Department of Primary Industries

OUT16/29518

**DPI response to request for comment on Environmental Assessment for
Bulli Seam Operations Project Modification (08_0150 MOD 2)**

Figure 3: Proposed gas drainage pipeline alignment

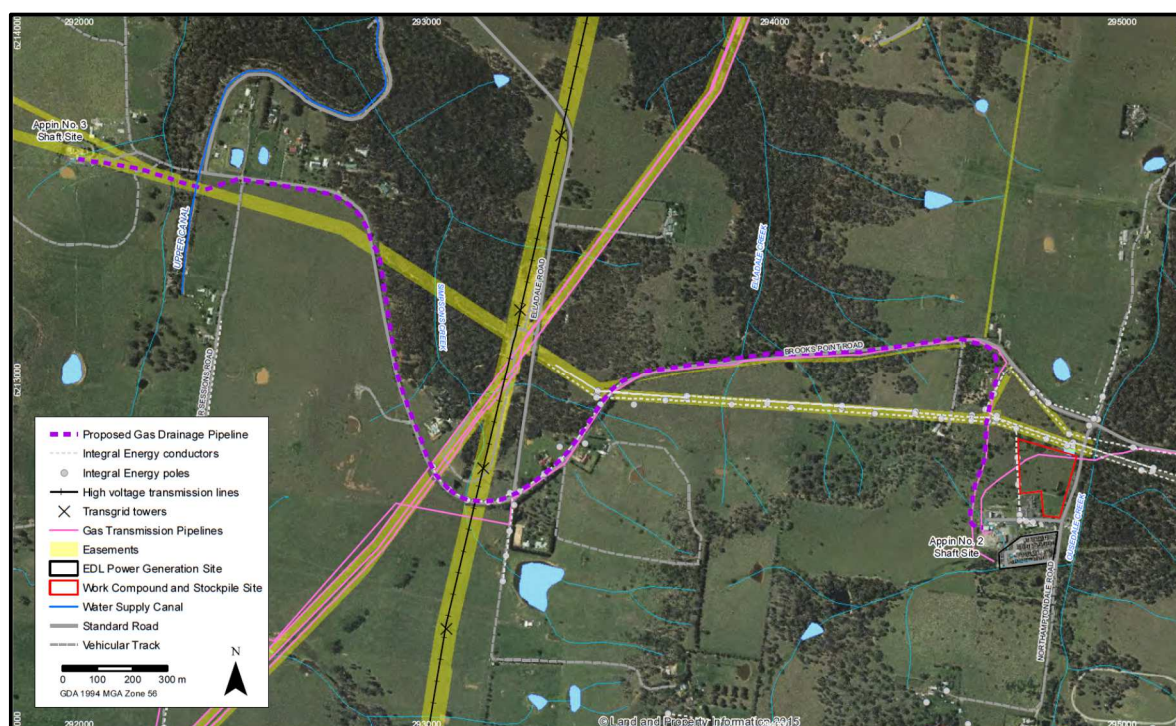
- Where the suction gas pipeline is to be trenched through first and second order watercourses, the proponent should ensure operations are consistent with requirements set out in [Controlled Activities on Waterfront Land. Guidelines for laying pipes and cables in watercourses on waterfront land, 2012](#).
- To manage the spread of any noxious weeds across properties, the Illawarra District Noxious Weeds Authority established under the *Noxious Weeds Act, 1993* should be consulted.
